MEMORANDUM

SUBJECT: SP-19-006 – Saddlehorn Ranch/824
First Submittal

Engineering Division

SHEET TITLE: SITE PLAN (NORTH)
SHEET NO. 2
2 OF 5 SHEETS
FILE NO. SP-19-006

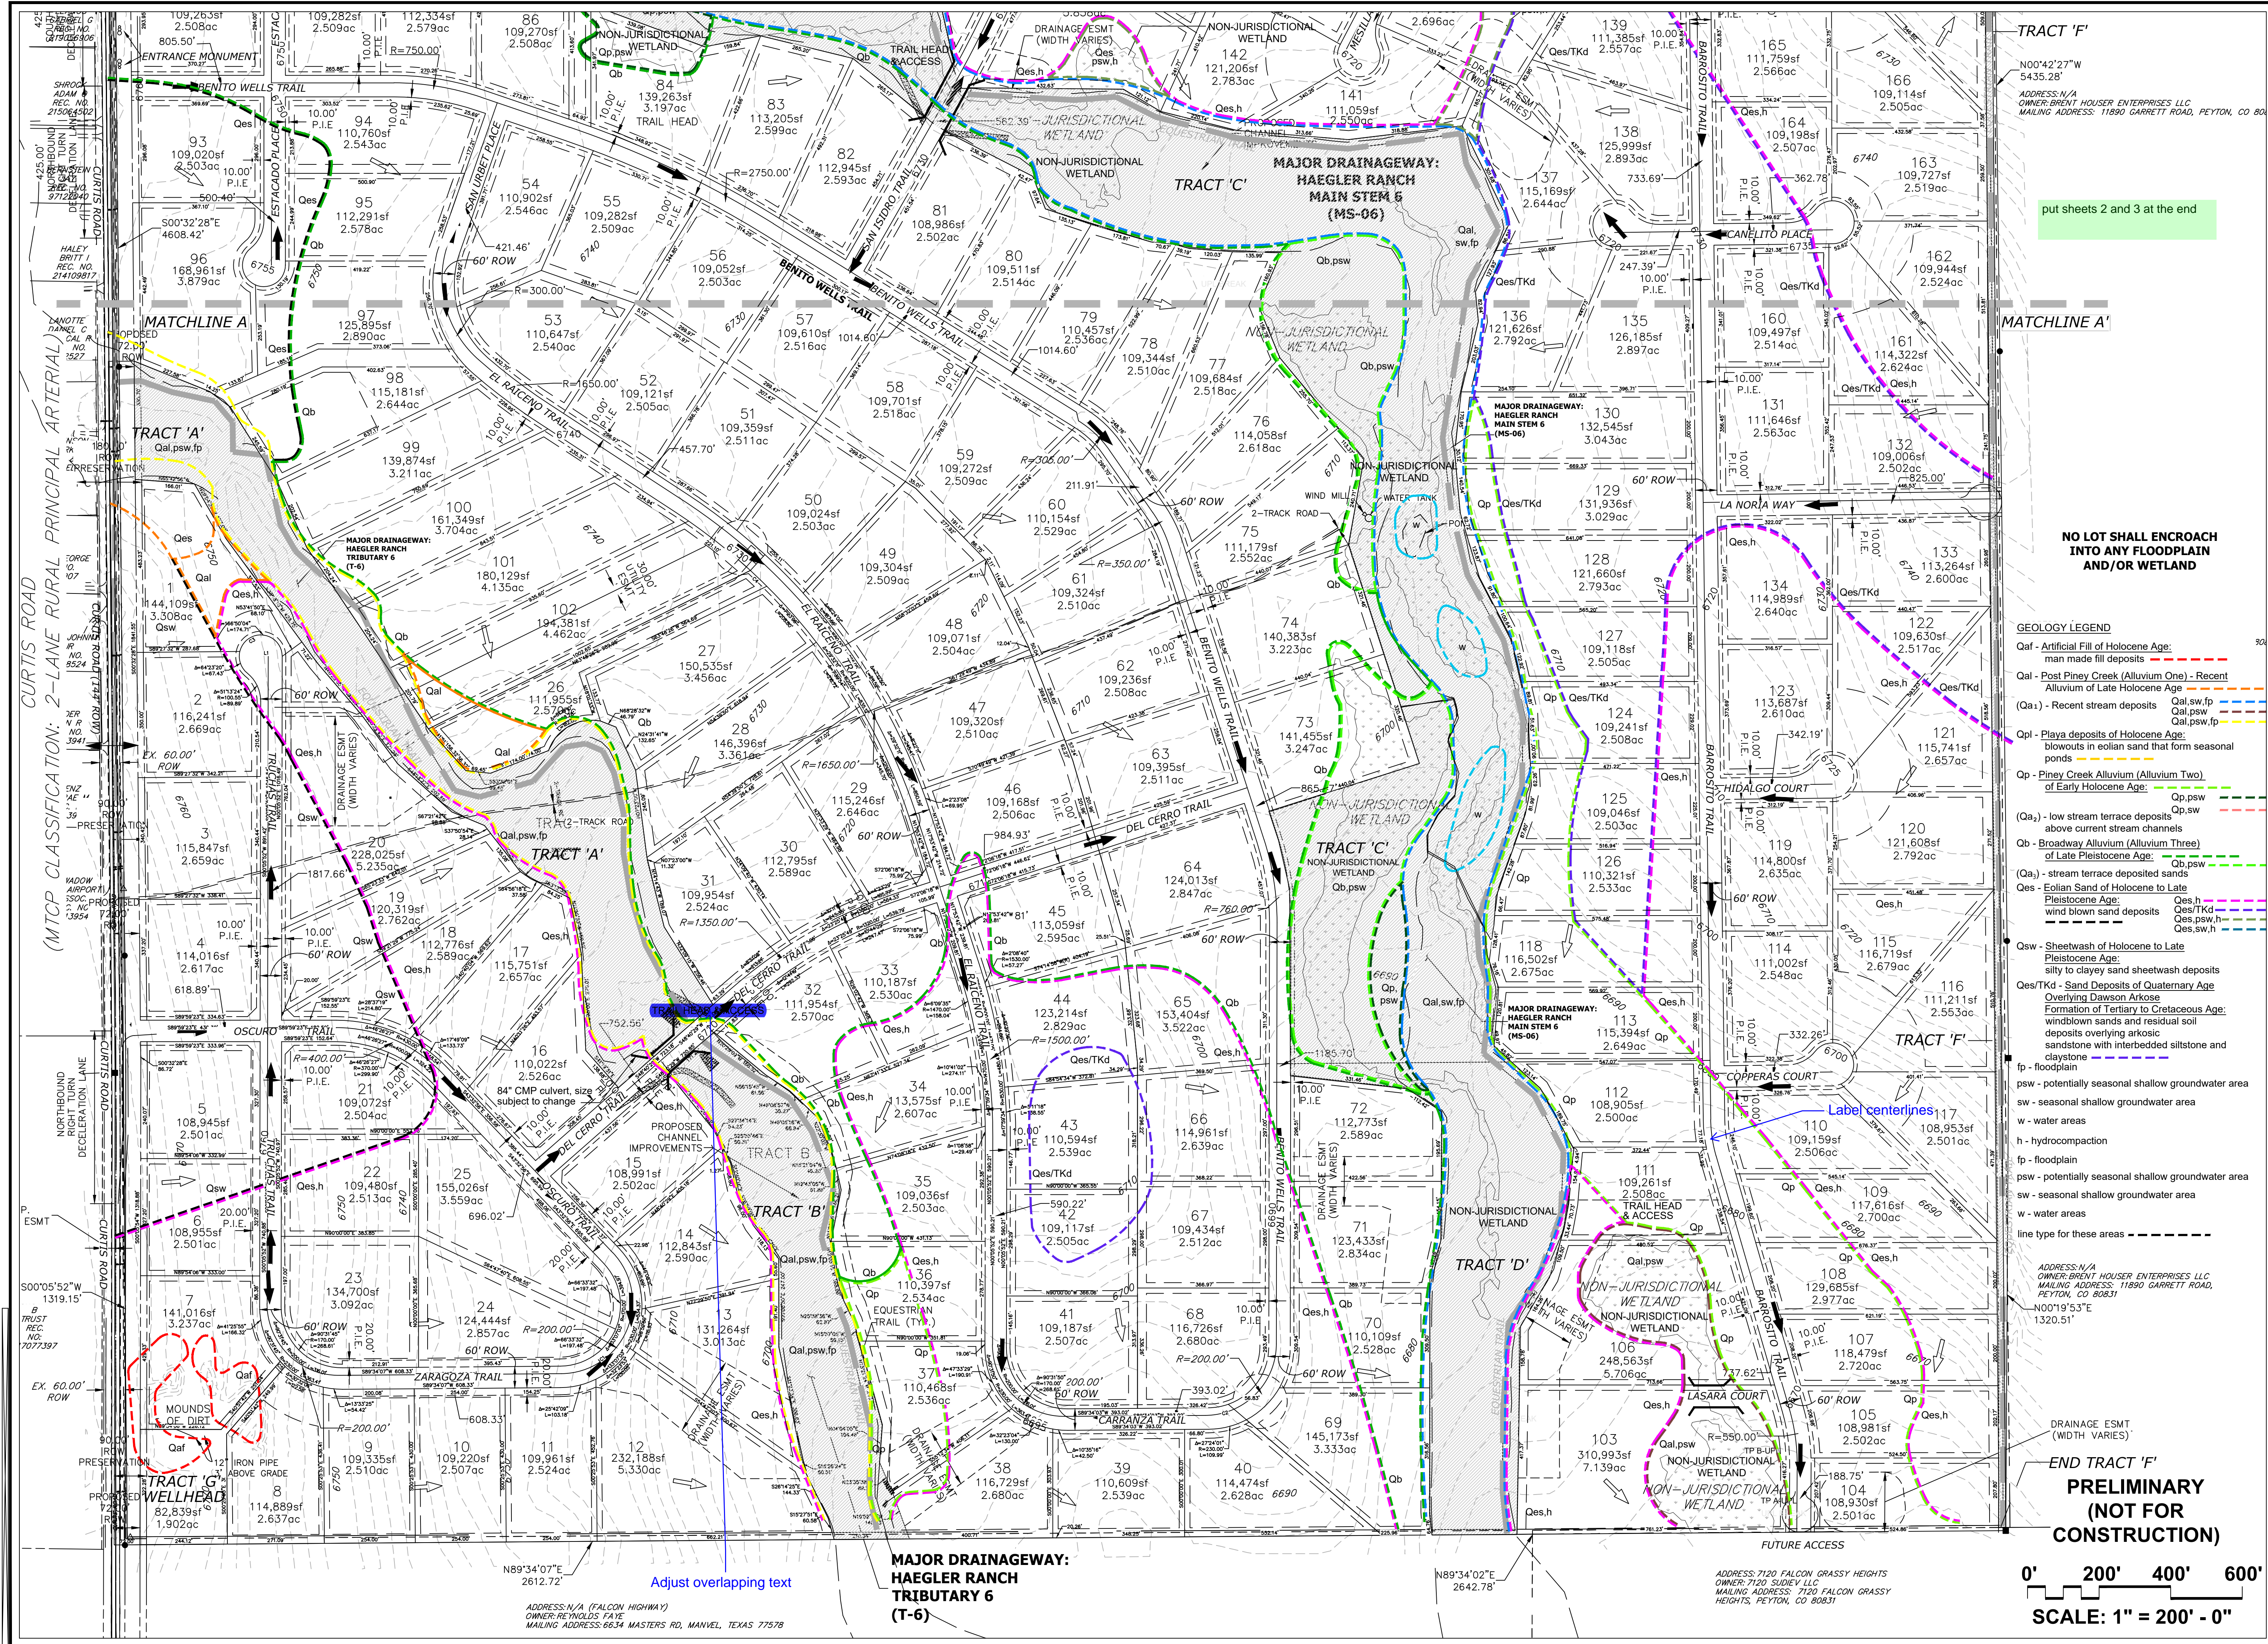
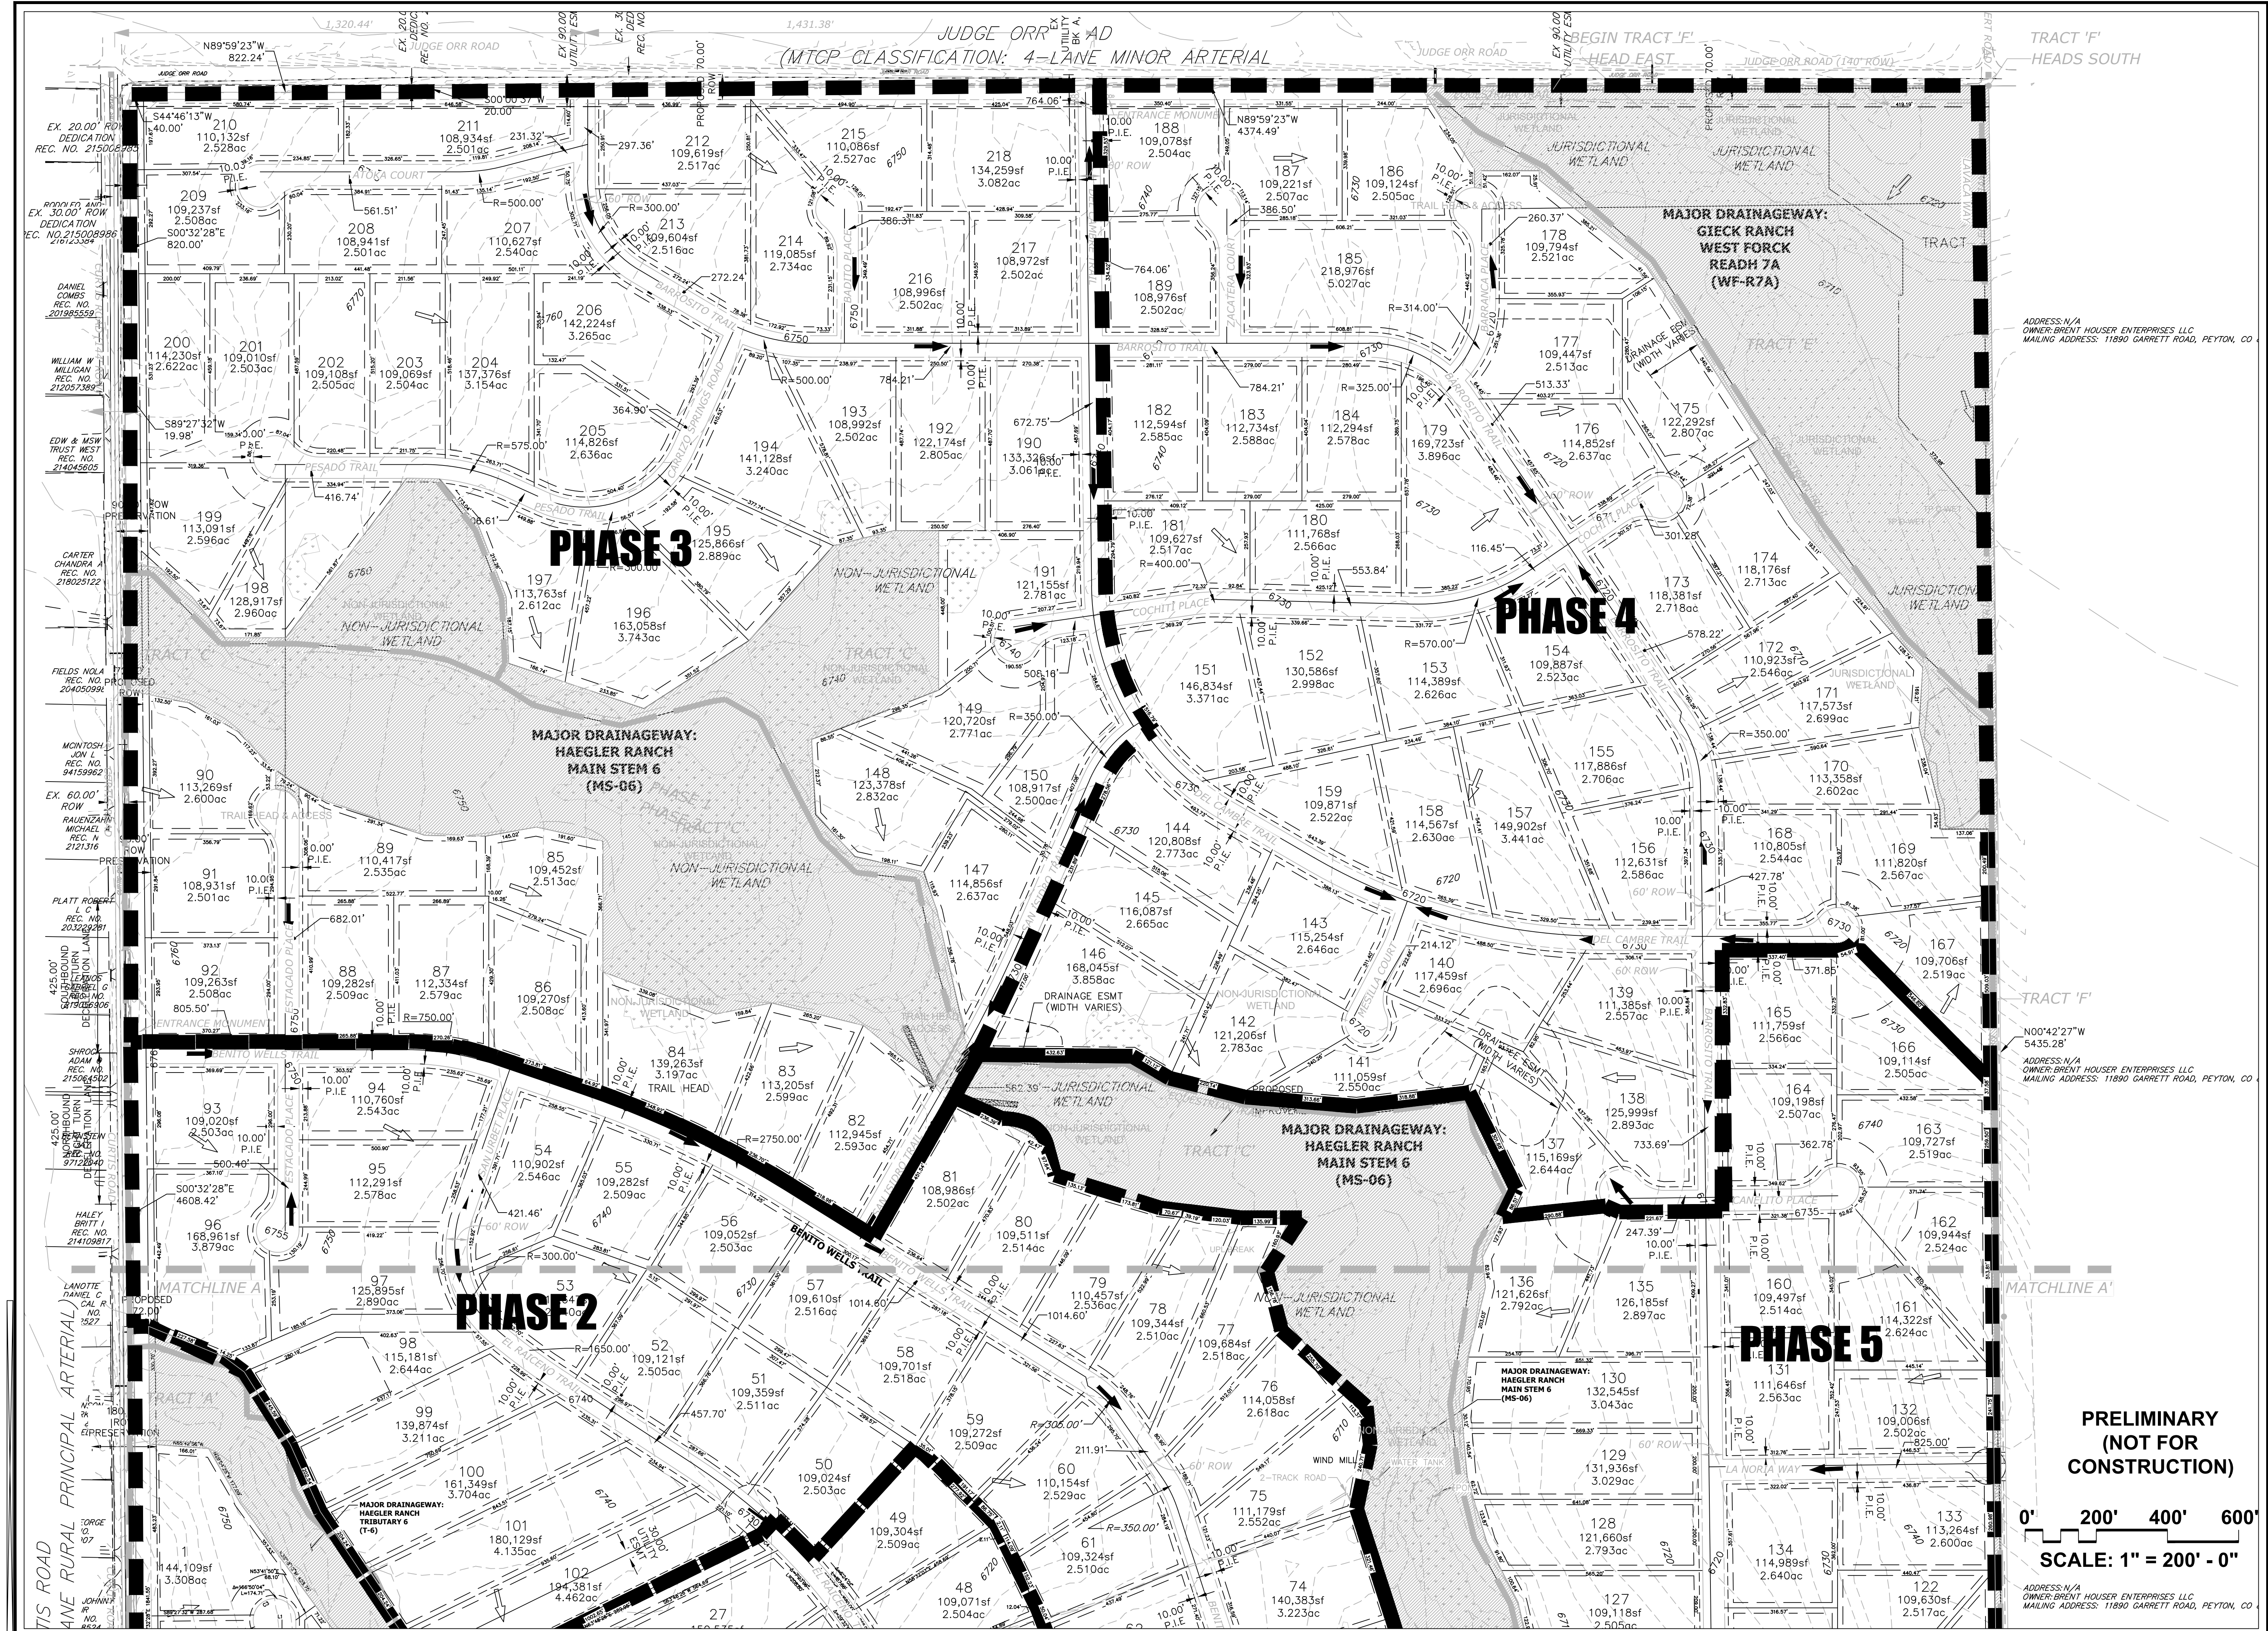
1. Label the Judge Orr Road and Curtis Road MTCP classifications, proposed rights-of-way and ROW preservation. Provide cross-sections (see TIS comment #1 below).
2. Show and label existing and proposed drainage facilities and all necessary drainage and maintenance access easements.
 - a. JR Response: Addressed.
3. Ensure that all checklist items are provided.
 - a) Guman response: checklist items provided.
4. Provide a note stating that approved Base Flood Elevations (BFEs) are required to be obtained for any plats in or within 300 feet of the northeast corner.
 - a) Guman response: This is called out on General note 18 on the cover sheet.
5. See preliminary plan redlines for additional comments.
 - a) Guman response: Redlined changes have been incorporated.
